**Re:** BusConnects Belfield/Blackrock to City Centre Core Bus Corridor Scheme  
Co. Dublin

The Merrion Road Residents' Association wish to lodge objections to elements of the planning application made by the National Transport Authority (NTA) in respect the proposed Blackrock to Merrion Core Bus Corridor (now incorporated into the Belfield/Blackrock to City Centre Core Bus Corridor Scheme)

The primary focus of the Residents' Association is the short stretch of road between Merrion Gates and Herbert Avenue/St Vincent's Hospital – generally sheets 10 and 11 in the relevant planning application documentation lodged with An Bord Pleanála refer.

Drawing File Name: BCIDC-ARP-TSM_GA-1415_XX_00-DR-CR-0010, Sheet Number: 10 of 24, Status: A, Rev: M01

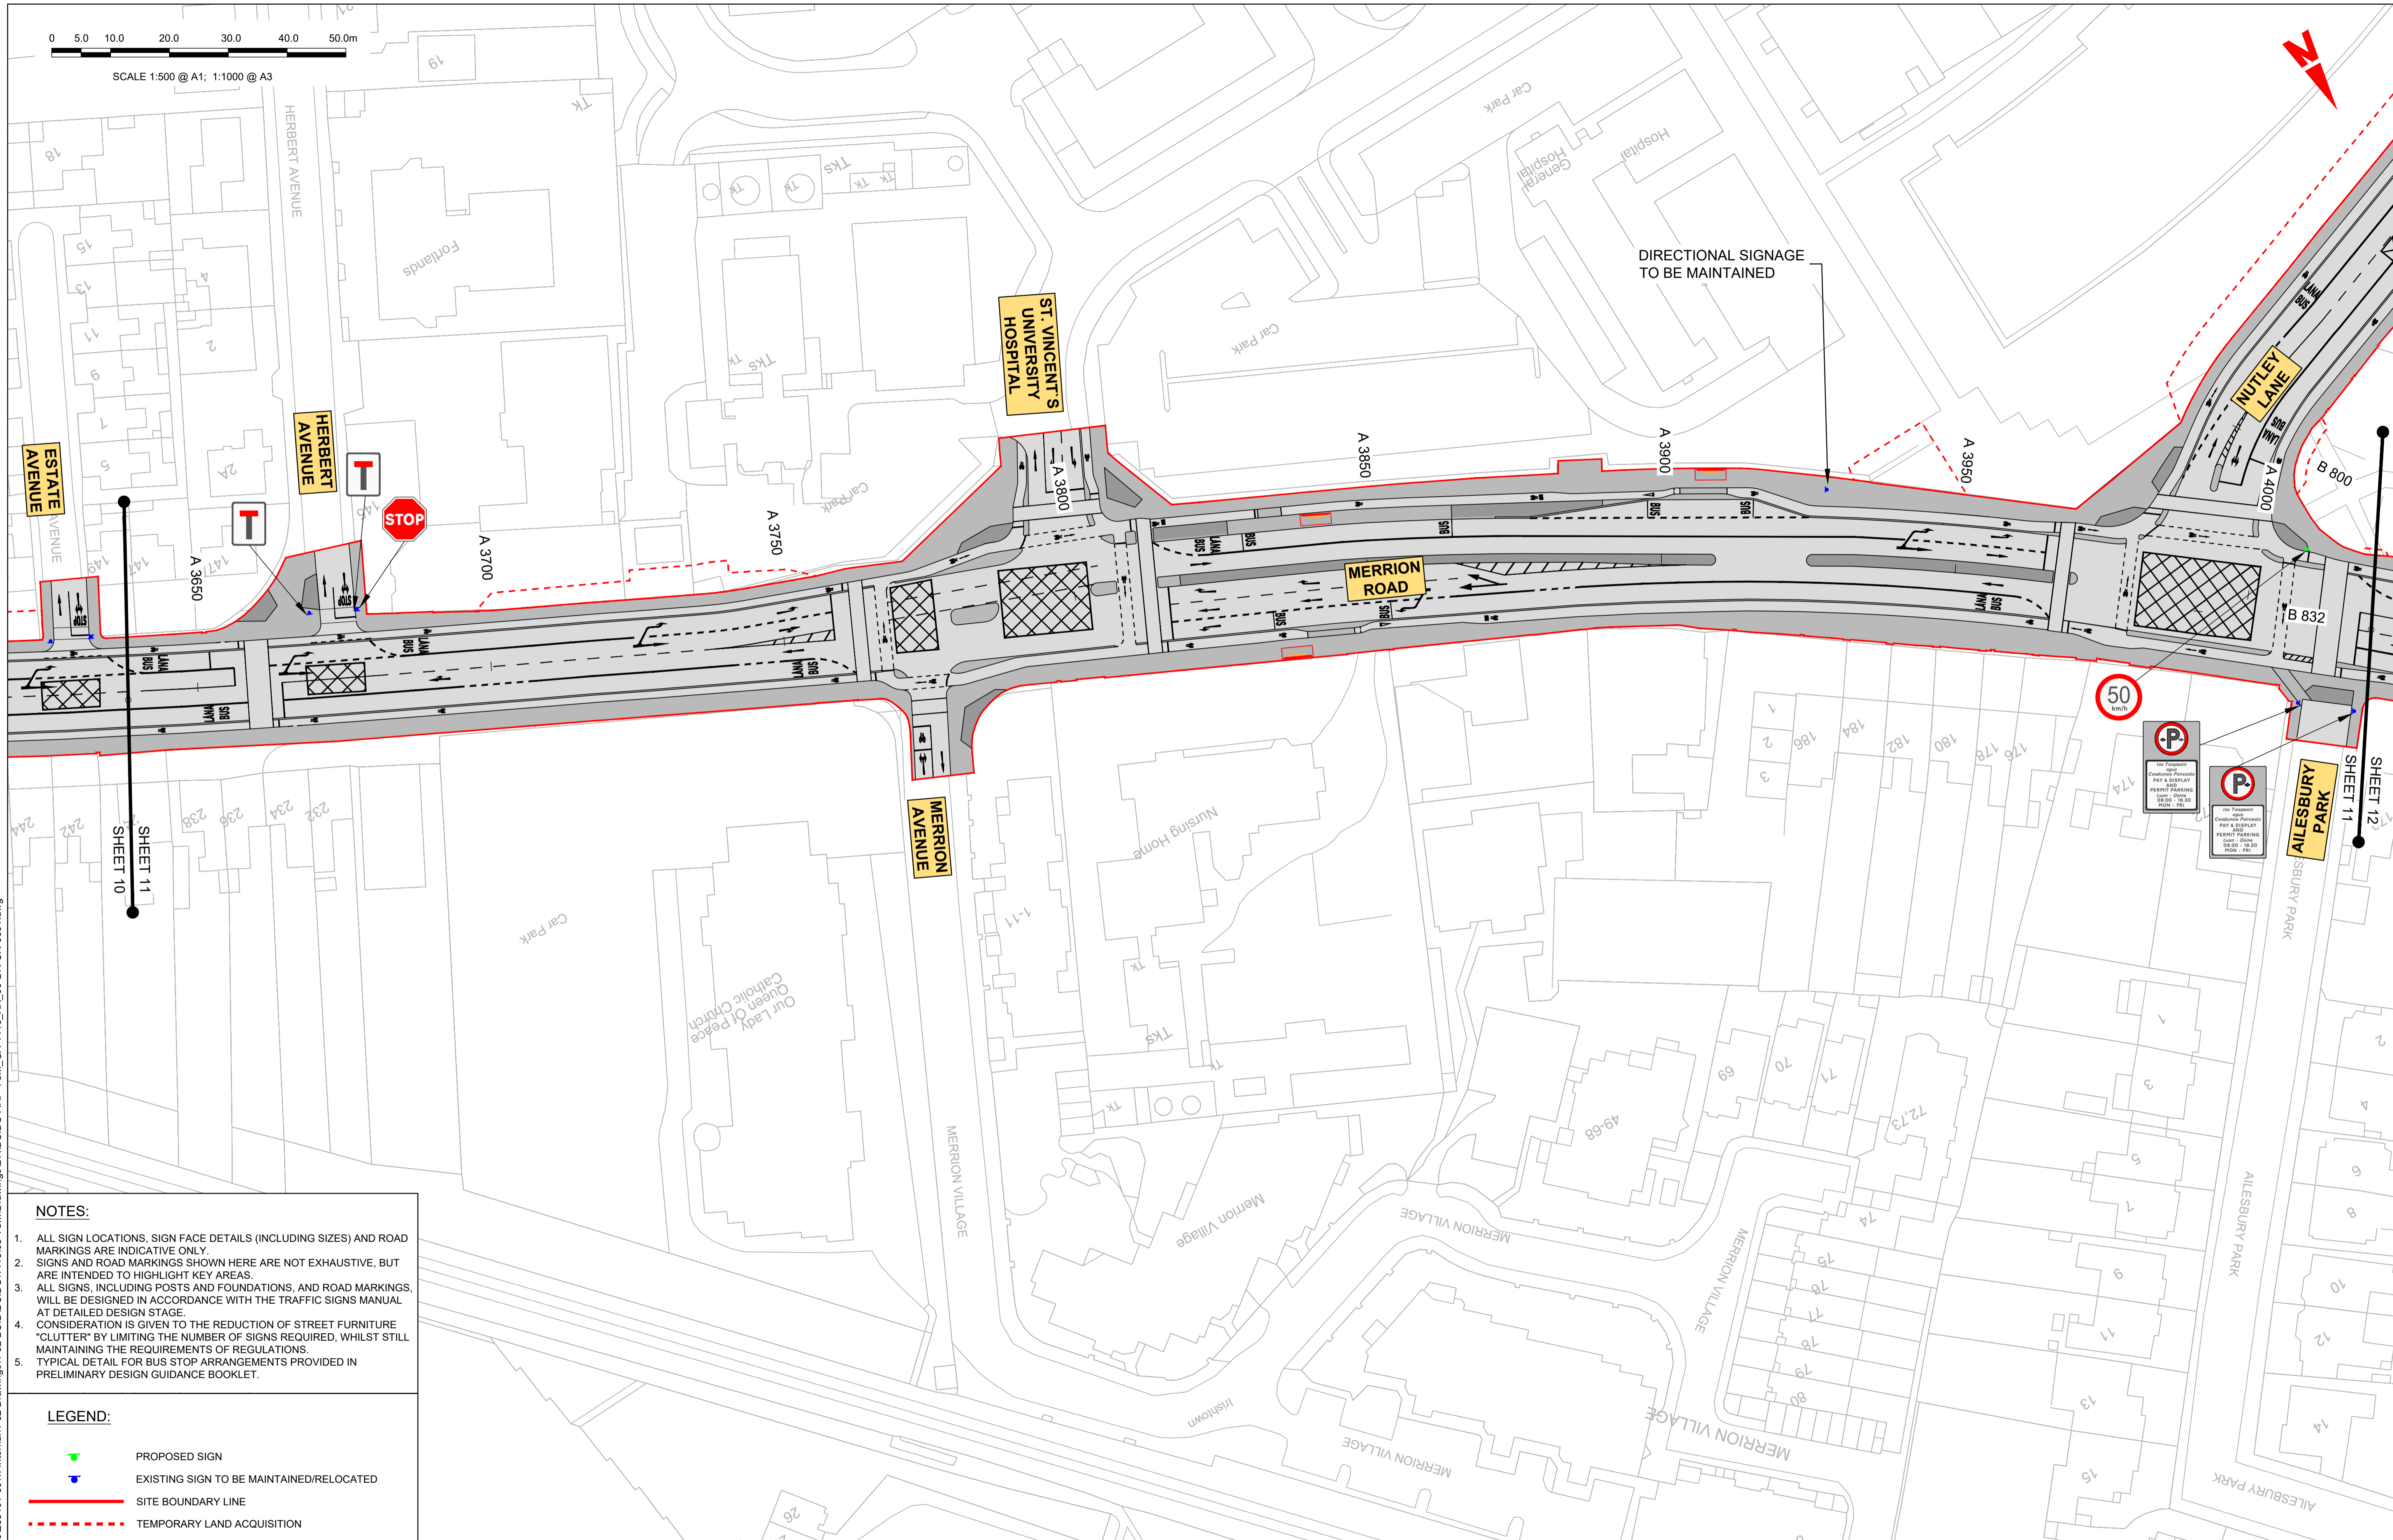
The Residents' Association is strongly of the view that the proposed 3-lane carriageway inbound (together with the associated priority signalling for inbound buses) from Merrion Gates to the Elm Court Apartments should be continued beyond the Apartments to the nearby junction at Estate Avenue.

- Negate the need to remove at least three (3) of the four (4) mature trees targeted for destruction;
- Negate the need for any alteration to the existing boundaries of protected structures – thus leaving the current architectural consistency of the streetscape (particularly in terms retaining the boundary 'balance' of the protected Pembroke Estate cottages at 153 and 151 Merrion Road with those at 149 and 147) intact.

**Mature Trees - Inbound:** As noted above, it is considered that the extension of the 3 lane/bus priority layout inbound from Elm Court Apartments to Estate Avenue would obviate the need to destroy at least 3 of these 4 very mature trees. It is noted that all of the trees are categorised in the Bus Connects planning application as being of Category A or Category B (i.e. good, healthy high-quality specimens).

**Mature Trees - Outbound:** The destruction of two (2) mature trees - both classed as good, healthy, high-quality specimens (1 Category A; 1 Category B) - is apparently being proposed in order to facilitate the provision of a 3-car parking bay. A parking bay in this location should be sized so as not to impact on the mature trees.

Any change to the existing boundaries of Nos 151 and [153 Merrion Road](#) would compromise the architectural symmetry of the Estate Avenue (formally Estate Cottages) enclave of protected structures. Originally Nos 147-153 Merrion Road were numbered 1-4 Estate Cottages. The proposal creates a mis-alignment between the boundaries of Nos 153 and 151 and that of Nos 149 and 147. This point was raised in the context of the Public Consultation Process but not specifically addressed by the NTA

**The Association requests that An Bord Pleanála reject the proposal to compulsorily acquire and alter the boundaries of Nos 153 and 151 Merrion Road.**

**In the context of pedestrian safety, it is requested that An Bord Pleanála enquire from the NTA whether it is feasible to place an outbound bus stop in or around Nos 266-270 Merrion Road - i.e. instead of the proposed 3 car parking bay and subject to the retention of the two mature trees. The original outbound bus stop (in the 1960s) was in fact in this location (not the current position of Stop No 423). If this is feasible, then the proposed stop to the south of Merrion Gates may not be required.**

The parking bay should be reduced to a 1- 2-car bay if this would negate the need to destroy the two mature trees.

Furthermore it would appear that an additional parallel parking bay could be provided on the inbound side of the Merrion Road in front of Elm Court Apartments as the bus stop (no 477) will be removed and there is a significant grass verge to facilitate a new footpath around any new parking bay. The adjacent mature tree should not be impacted and the current line of sight for those exiting Elm Court Apartments should not be adversely impacted given the removal of the Bus Stop (and if the parking bay is made as 'deep' as practicable).
